Pear tree Hill Solar Farm

Environmental Statement Addendum

Revision ~~7~~8 (tracked)

Application Document Ref: EN010157/APP/8.2

Figure 7.1: Designated Sites and Ecological Mitigation and Enhancement Areas

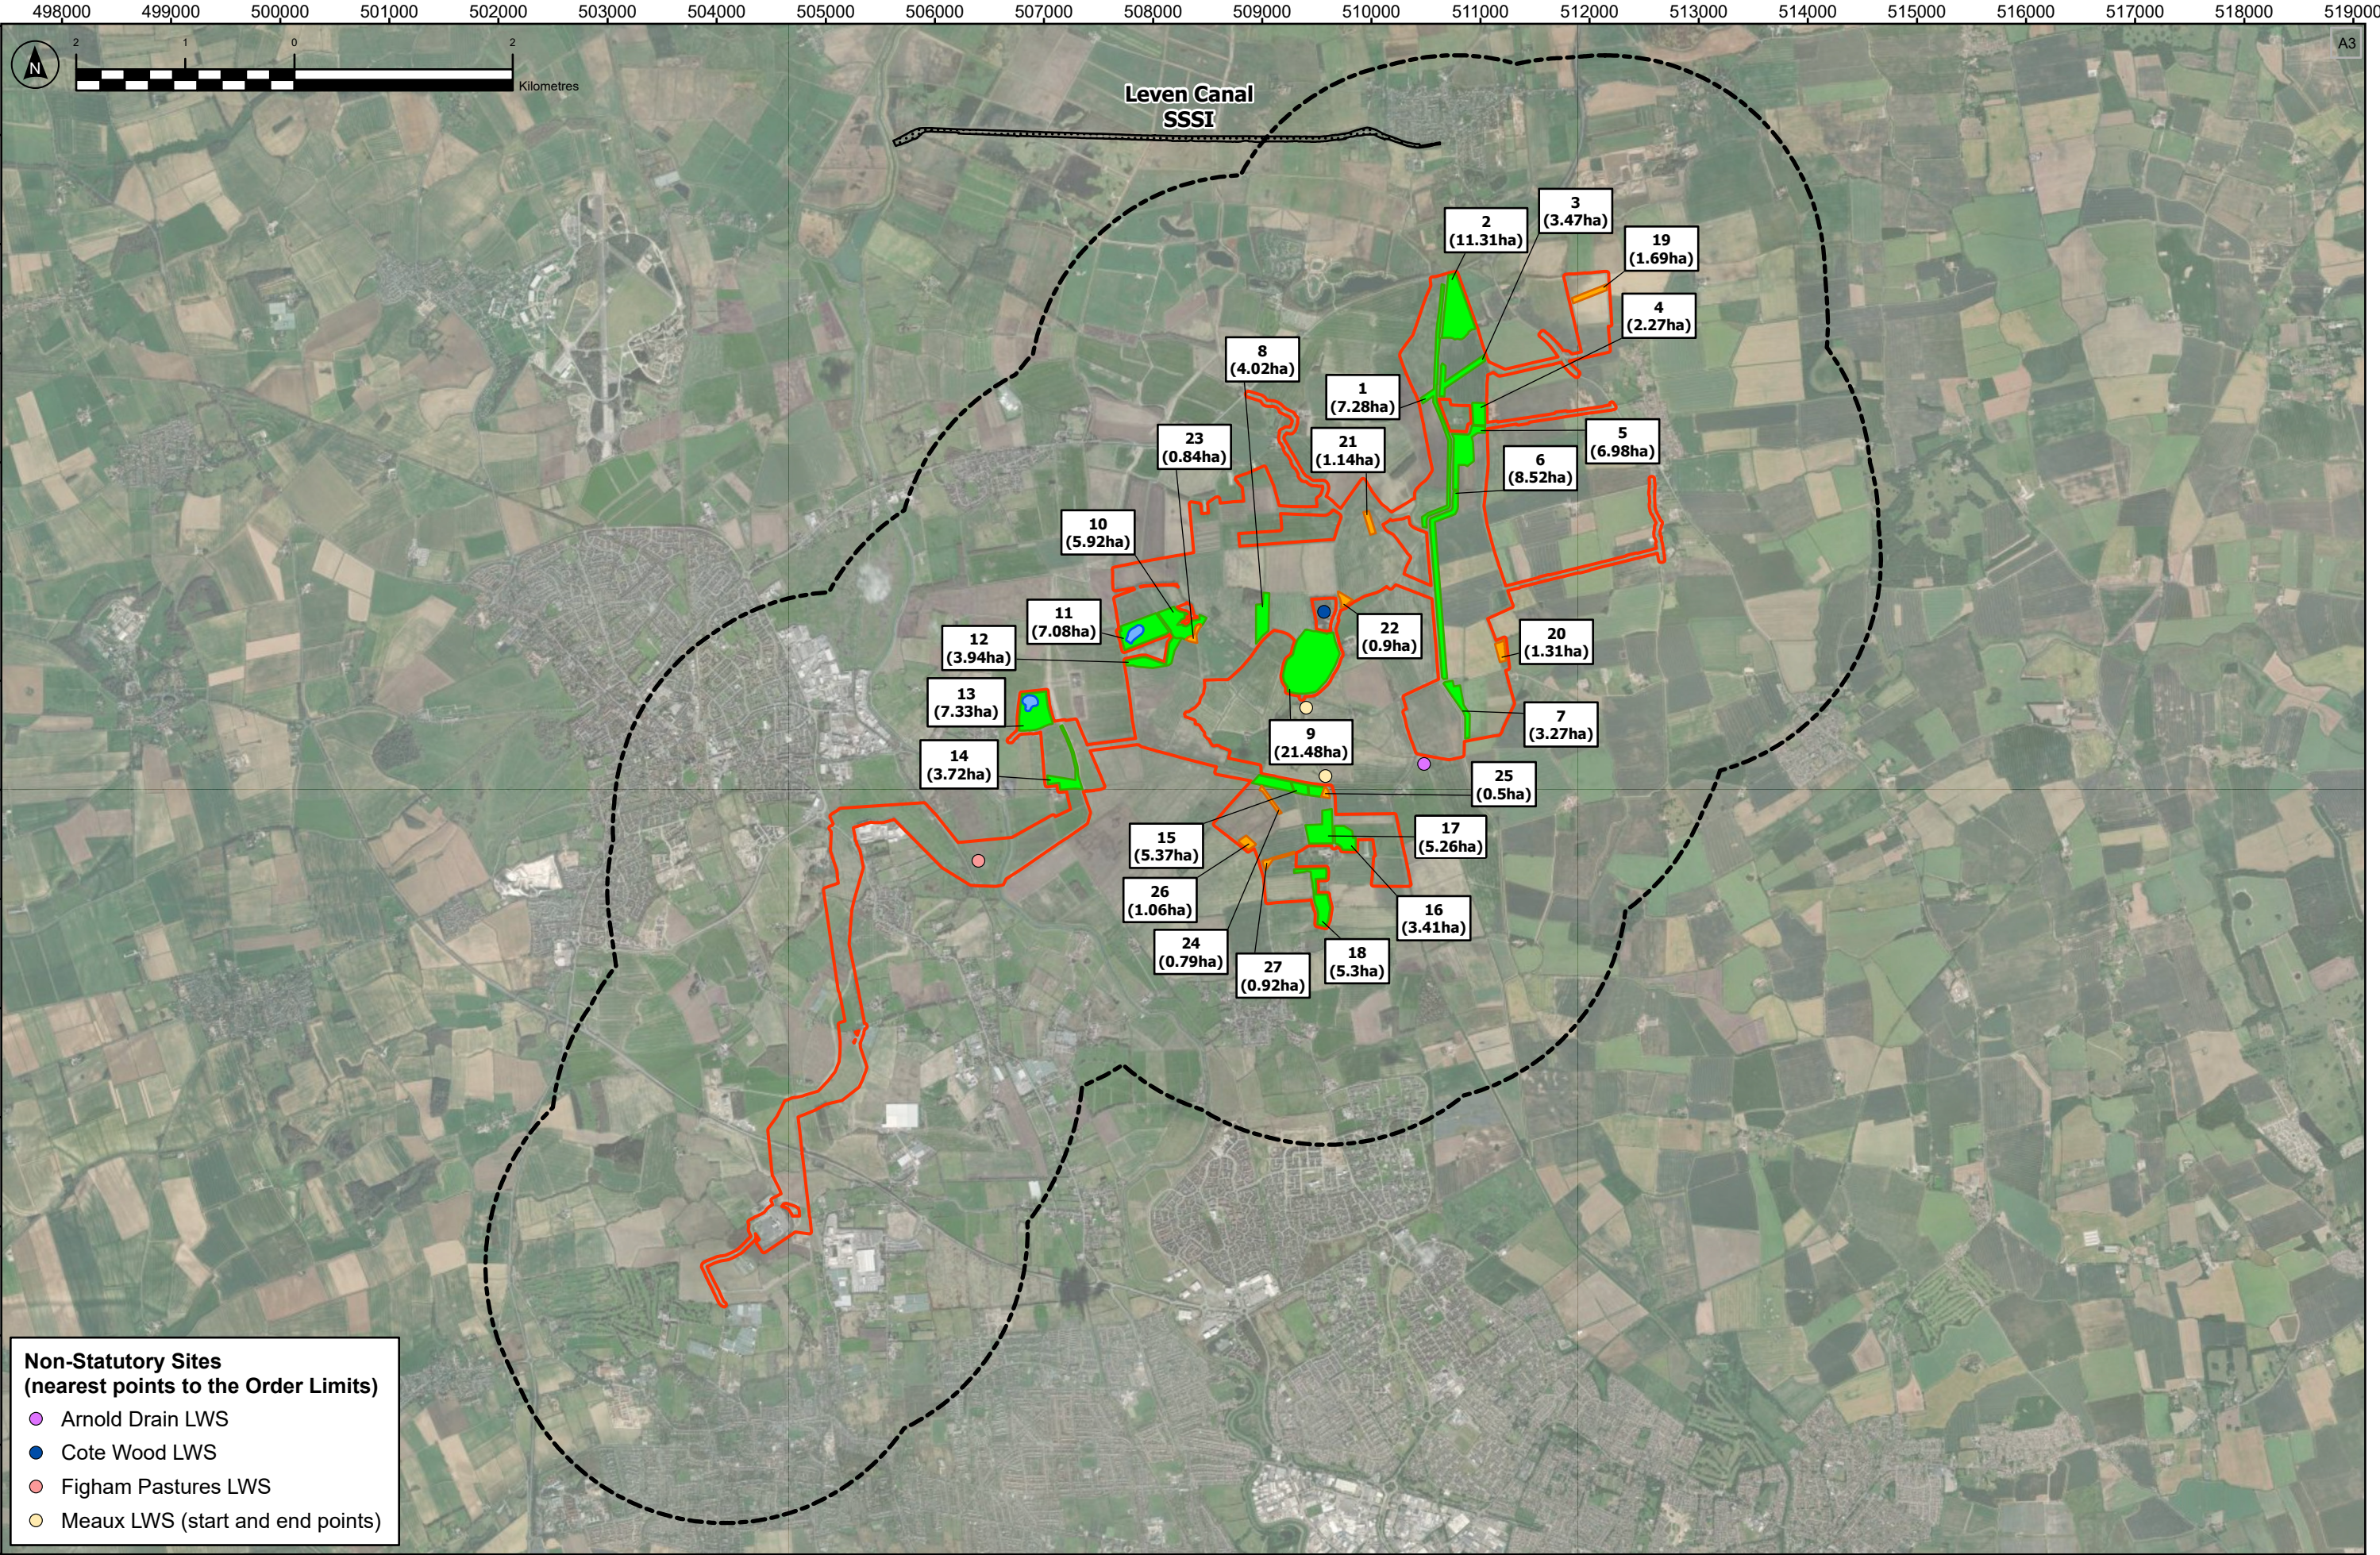
ES Volume 3, Figure 7.1: Designated Sites and Ecological Mitigation and Enhancement Areas [APP-065]	Figure 7.1 requires amendment to reflect the removal of plots 10-4, 10-5 and 10-6 as part of change/correction 2.	
ES Volume 3, Figure 7.2: Biodiversity Study Areas [APP-066]	Figure 7.2 requires amendment to reflect the removal of plots 10-4, 10-5 and 10-6 as part of change/correction 2.	
ES Volume 3, Figure 9.1: Cultural Heritage Study Areas [APP-067]	Figure 9.1 requires amendment to reflect the removal of plots 10-4, 10-5 and 10-6 as part of change/correction 2.

Figure 9.2: Assessed Designated Heritage Assets

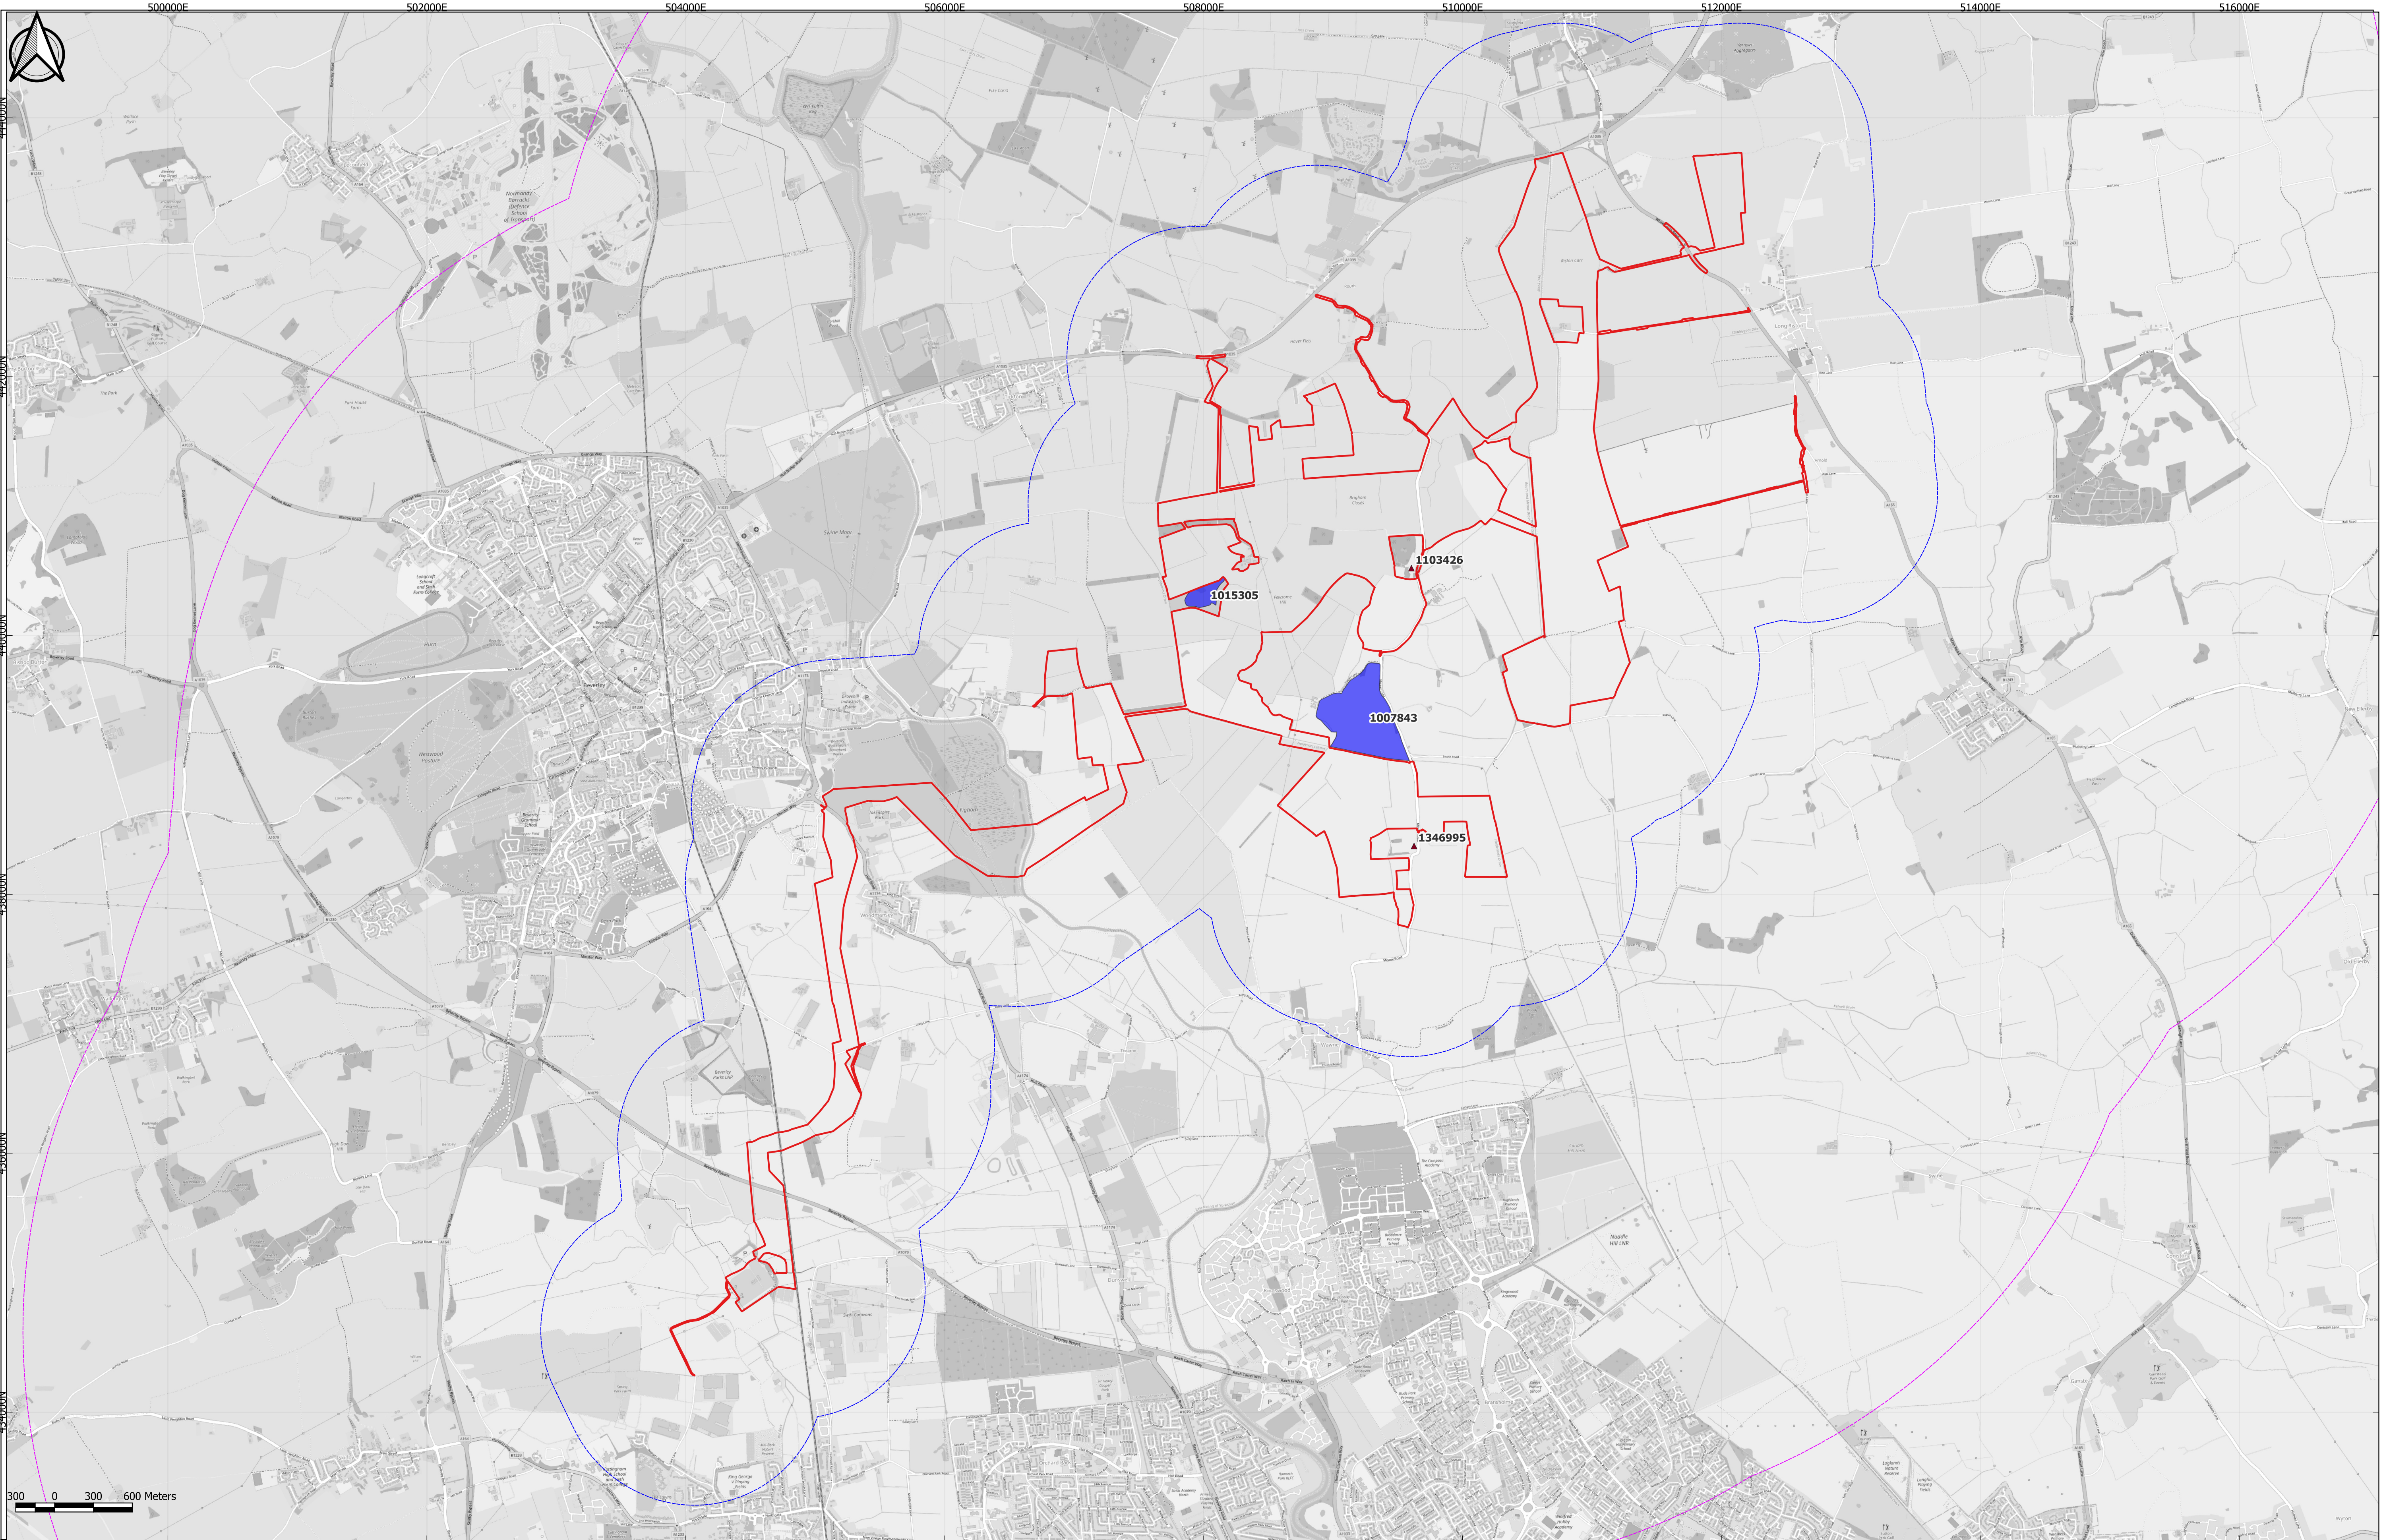
Document reference	Reason for amendment	ES Amendment July 2025
ES Volume 3, Figure 9.2: Assessed Designated Heritage Assets [APP-068]	Figure 9.2 requires amendment to reflect the removal of plots 10-4, 10-5 and 10-6 as part of change/correction 2.	
ES Volume 3, Figure 9.3: Assessed Non-Designated Heritage Assets [APP-069]	Figure 9.3 requires amendment to reflect the removal of plots 10-4, 10-5 and 10-6 as part of change/correction 2.	
ES Volume 3, Figure 10.1: Study Areas and Key Features for Land, Soil and Groundwater [APP-070]	Figure 10.1 requires amendment to reflect the removal of plots 10-4, 10-5 and 10-6 as part of change/correction 2.	
ES Volume 3, Figure 10.2: ALC Blocks overlaid Land Areas [APP-071]	Figure 10.2 requires amendment to reflect the removal of plots 10-4, 10-5 and 10-6 as part of change/correction 2.	
ES Volume 3, Figure 11.1: Landscape Study Area, Context, Designations and Access [APP-072]	Figure 11.1 requires amendment to reflect the removal of plots 10-4, 10-5 and 10-6 as part of change/correction 2. Figure 11.1 also requires amendment to reflect the removal of a section of solar array from Land Area B as part of change/correction 1.
